**Consultation Response from KC,
Highways Development Management**

2024/93017 51, Longcroft, Almondbury, Huddersfield, HD5 8XW

Conversion of garage to habitable accommodation and erection of fence

Revised Drawing Response

Block Plan - 1:500

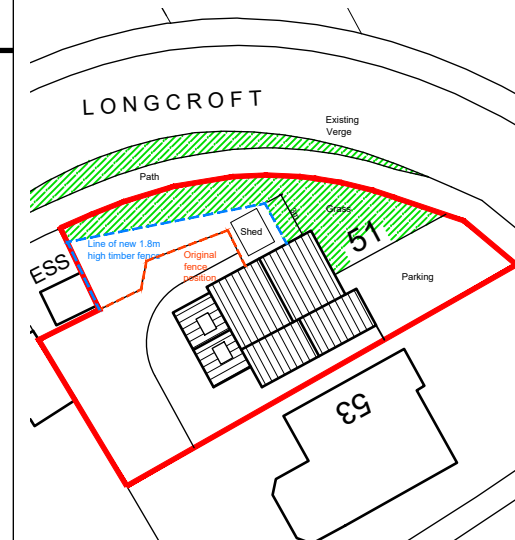
In the revised drawing the fence line has been shown to be offset by approximately 1m along the side connecting to the electricity sub-station. This would now allow for a 25m visibility splay to the right for vehicles exiting the garage/parking space for No 55 Longcroft, however we would request that a condition is added to ensure that anything within the area between the fence and the rear of the adopted footway is maintained to a maximum height of no greater than 1m to ensure clear visibility for drivers.

The 1m offset will also allow an increase of forward visibility around the bend on Longcroft adjacent to the application site.

Greater concern has been raised about the line of the new 1.8m high fence surrounding the property. This has already been erected and so is submitted for retrospective permission, however drawing No 0302-P02 shows that the line of the fence is to be amended and angled inwards from the adopted highway. This angled alignment, although still limiting visibility more than before the fence was built, will allow for forward visibility of approximately 25m around the bend from the nearside kerb as prescribed in Manual for Streets and the Kirklees Highways Design Guide. For a 20mph road the guideline forward visibility length is 24.87m and so this is acceptable.

However, the location of the fence does reduce the visibility splay to the right for vehicles exiting the parking space/garage for No 55 Longcroft to only 17m and this would be below the recommended visibility splay y-length of 25m. In order to achieve this, the fence within the visibility splay for the garage at No 55 would need to be lowered to under 1m or the boundary of the fence moved inwards approximately 1m towards the electricity sub-station, allowing for a 1m grass strip between the fence and the rear of the footway at this location. Any planting within this 1m strip should be kept to below 1m in height by planning condition.

Until the full visibility splays can be clearly shown for the garage at No 55 we would not be able to support the application on highway safety grounds.

With this we are satisfied that the forward visibilities and the visibility splay for vehicles exiting the garage at No 55 are within standards and therefore would not like to object to the application but

Upon completion of the fence works as shown in approved drawing 0302-P03, sightlines along the frontage of the site between the fence line and the rear of the adopted highway on Longcroft shall be cleared of all obstructions to visibility exceeding 1 m in height and these shall be retained free of any such obstruction throughout the lifetime of the development.
